APPLICATION SUBMITTED UNDER SECTION 96A OF THE TOWN AND  
COUNTRY PLANNING ACT (1990) AS AMENDED

APPLICATION FOR NON-MATERIAL AMENDMENT Erection of 3no  
industrial/warehouse units ( Use classes B2 and B8 and E(g)(ii) and E(g)(iii) totalling  
11,585 sqm floorspace and associated works including provision of access, parking  
and landscaping (Amended Plans)

Land at Land at Dearne Valley Parkway, Hoyland, Barnsley S74 0QAI

I refer to the above referenced application for a Non-Material amendment to planning  
permission reference 2021/0479 granted on 10/02/2023.

Unit 1 - Elevations

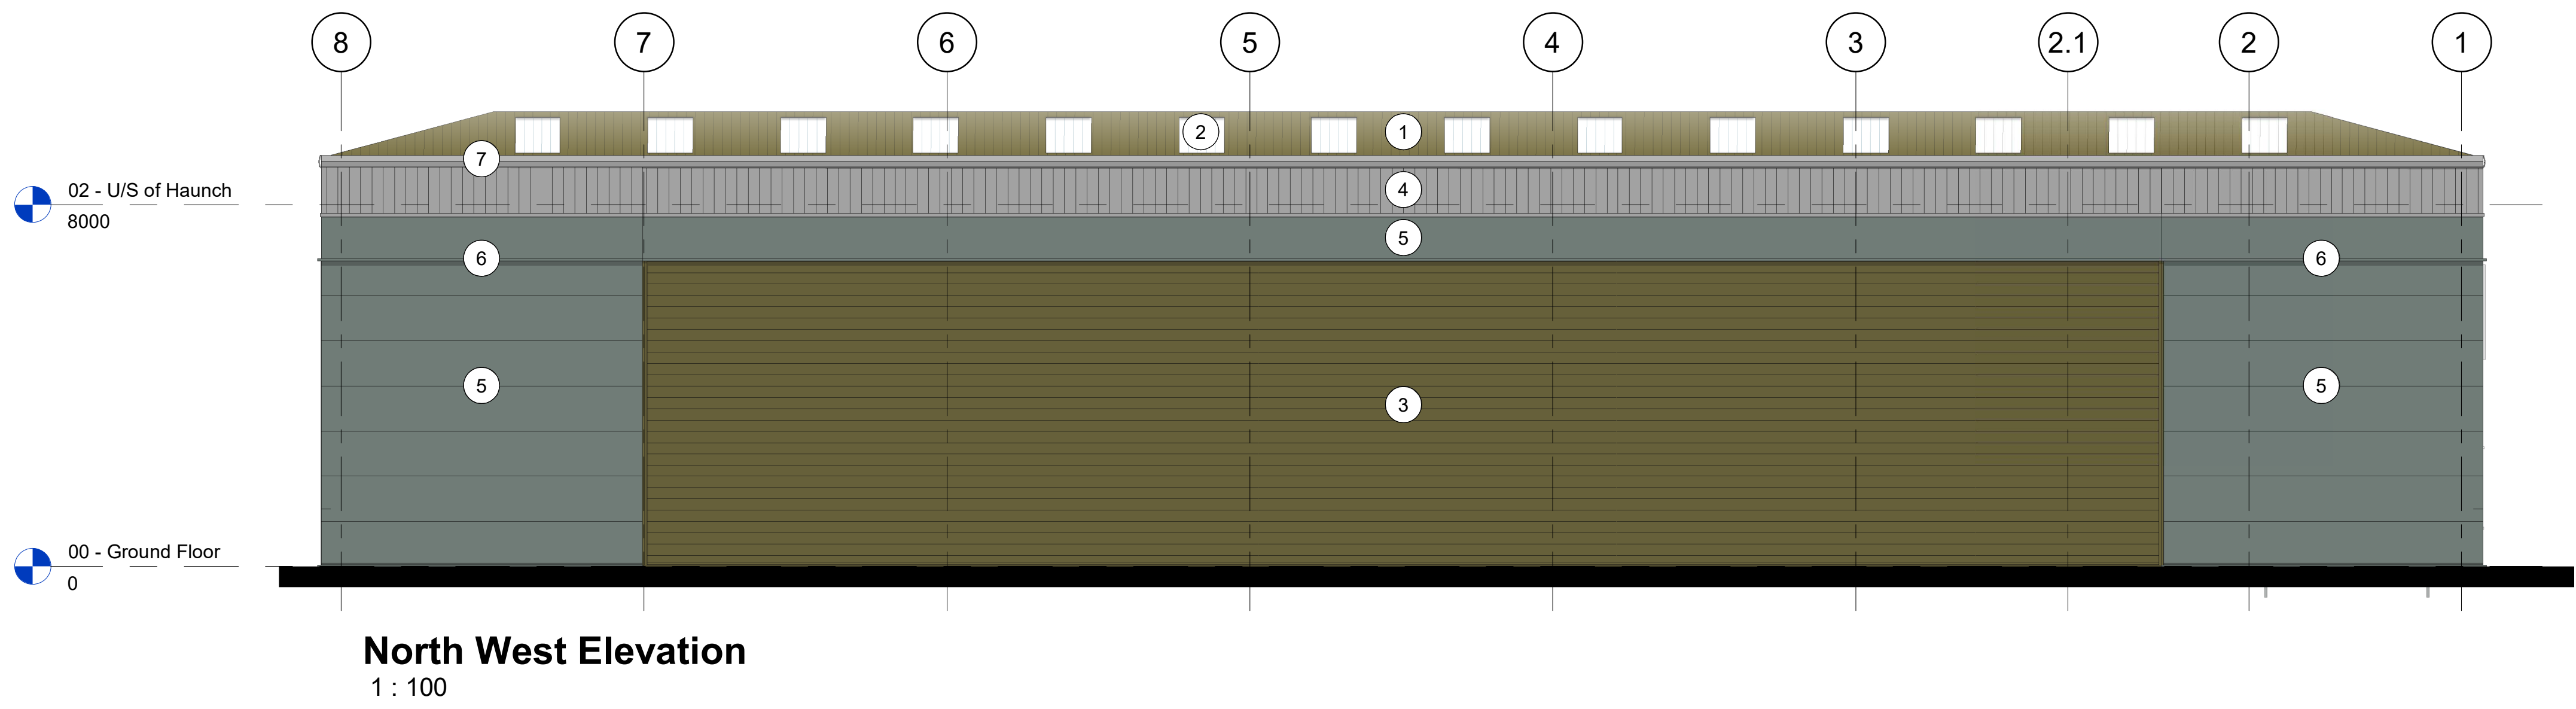
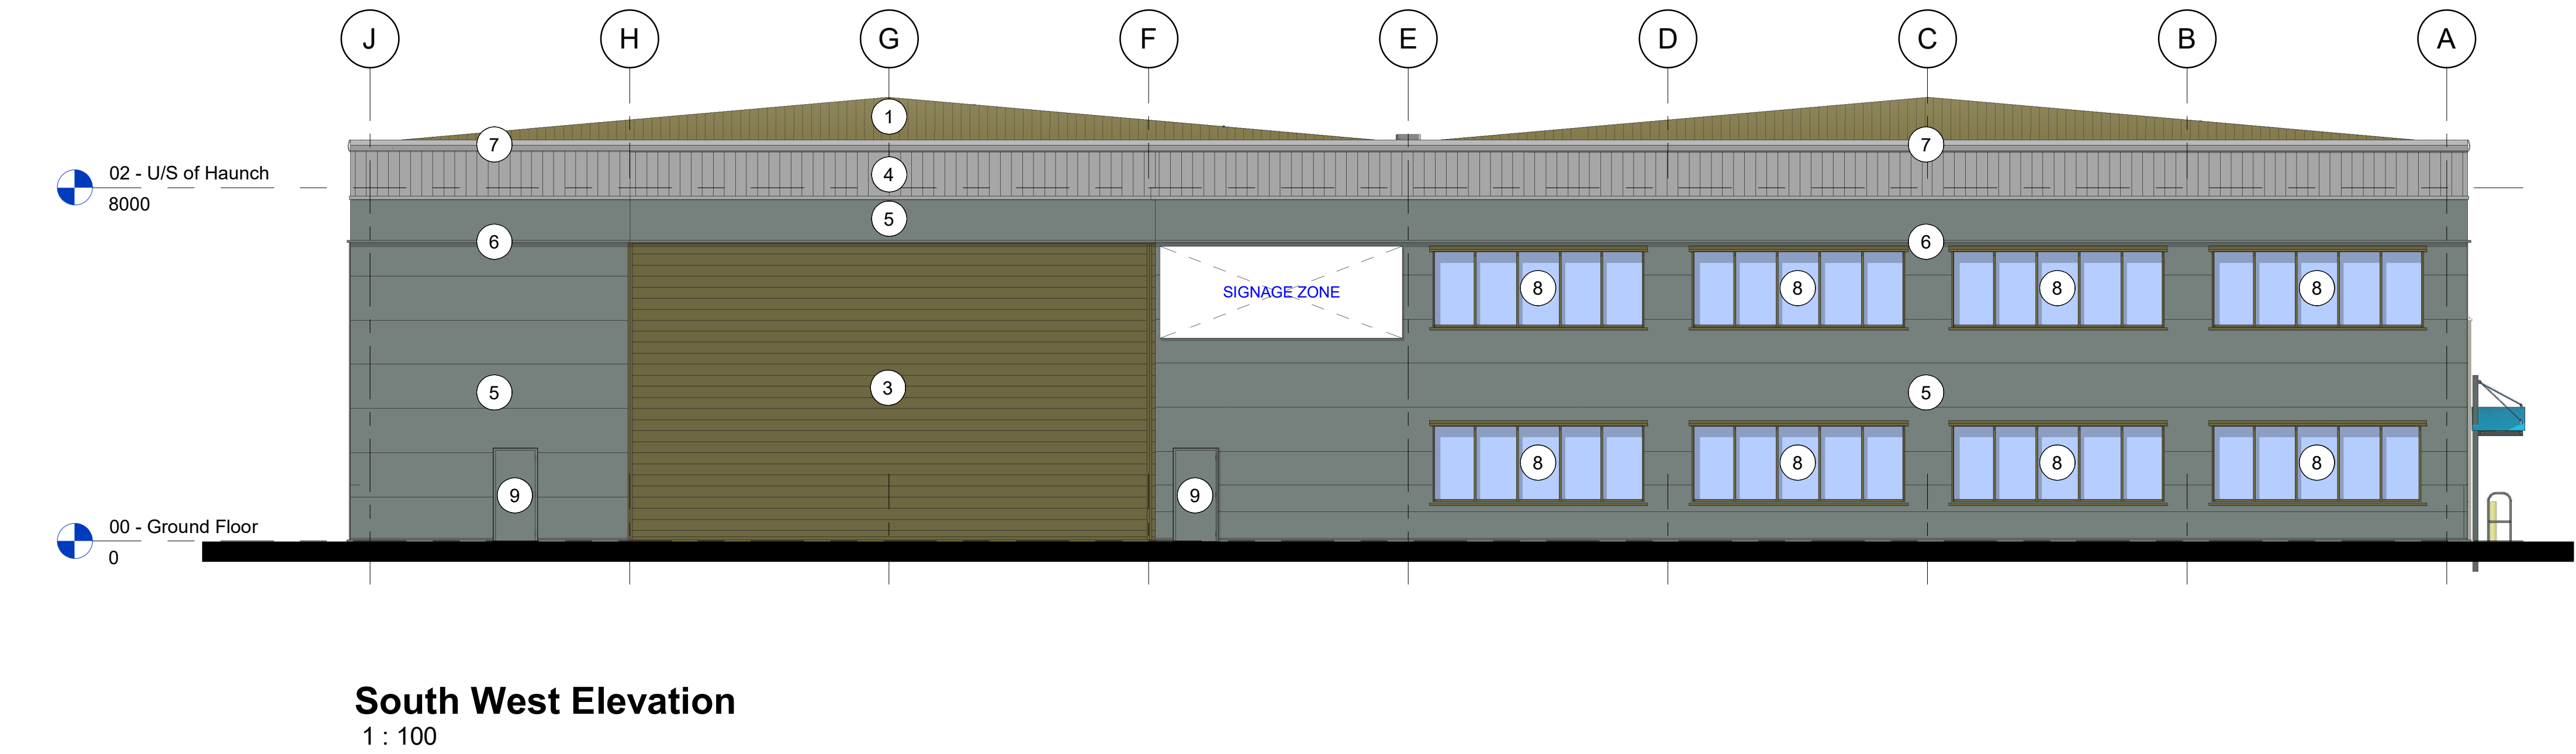
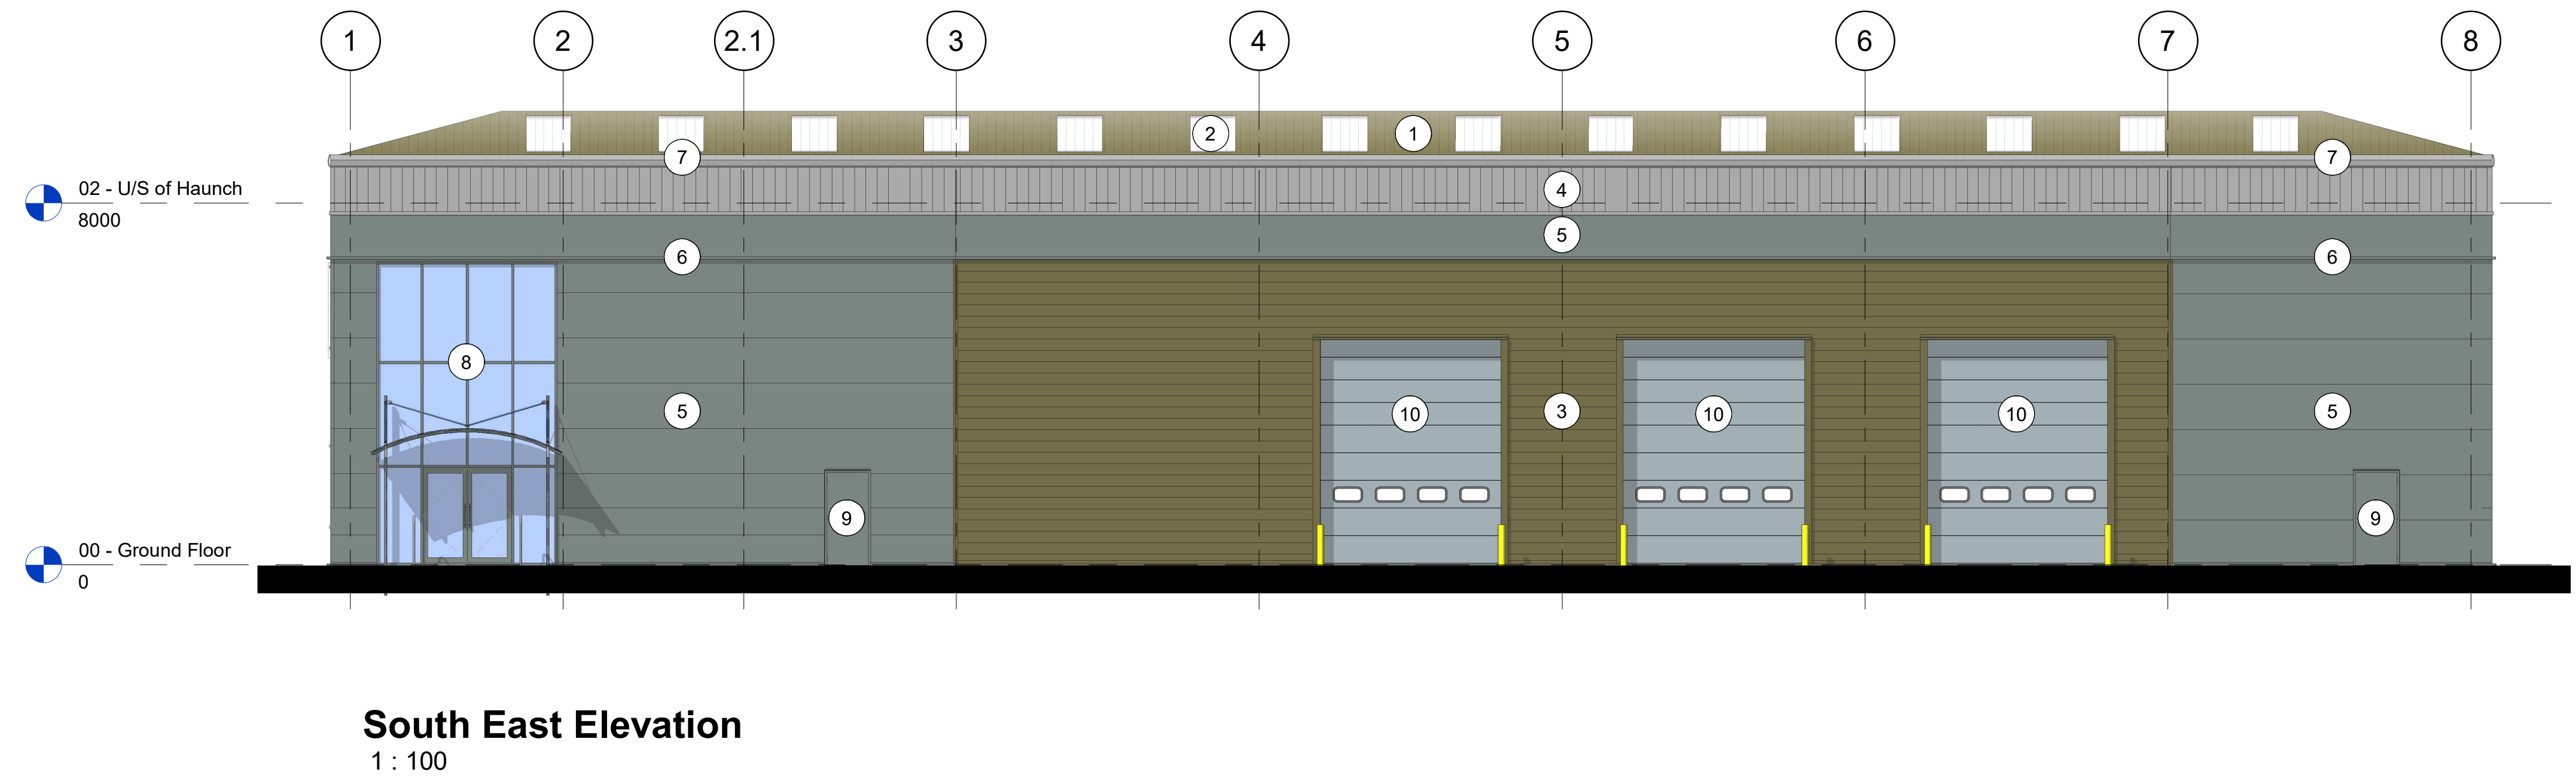
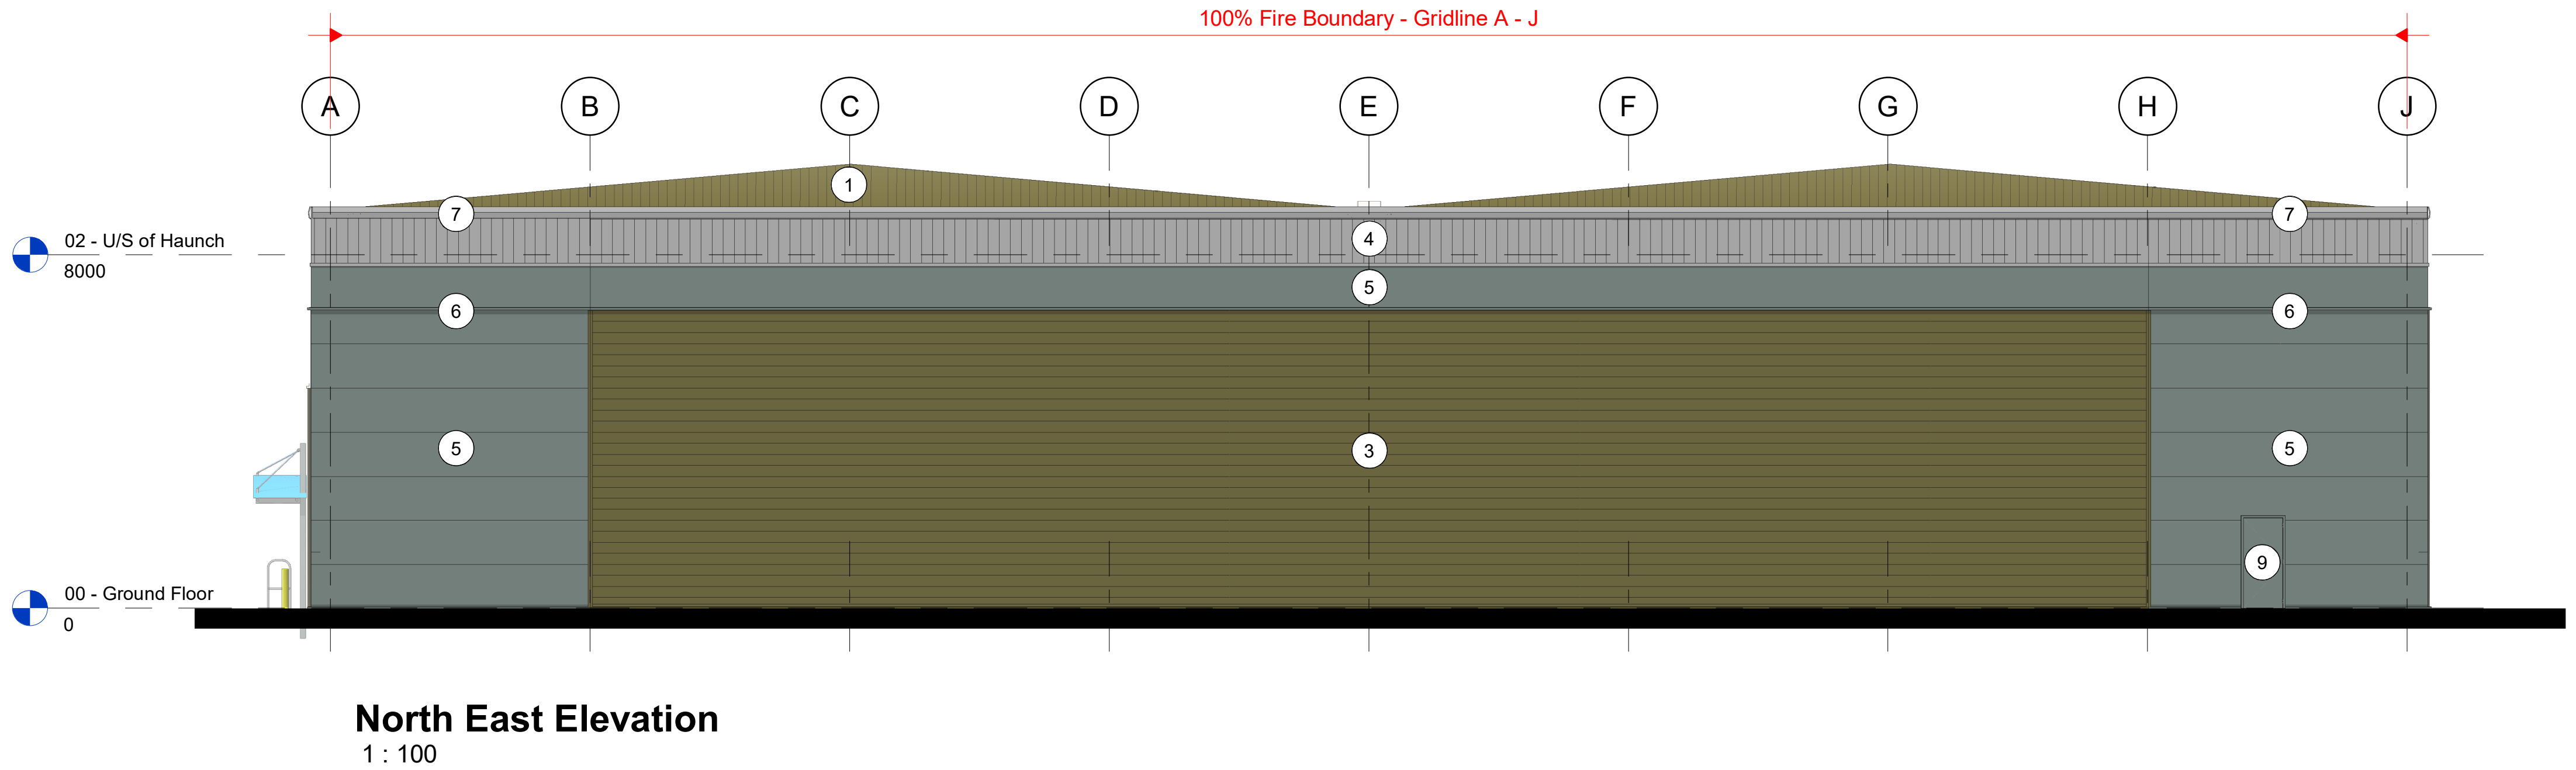
The changes proposed by the Non- Material Amendment are:

- To remove the olive green clad cladded infills between windows
- Replace the entrance canopies with free standing ones
- To amend elevations from 'Goosewing Grey' (RAL 080 70 05) be changed to the colour 'Pure Grey' (RAL 000 55 00)

Unit 1 Elevations 3061-1-301(P2) received 26/06/2025
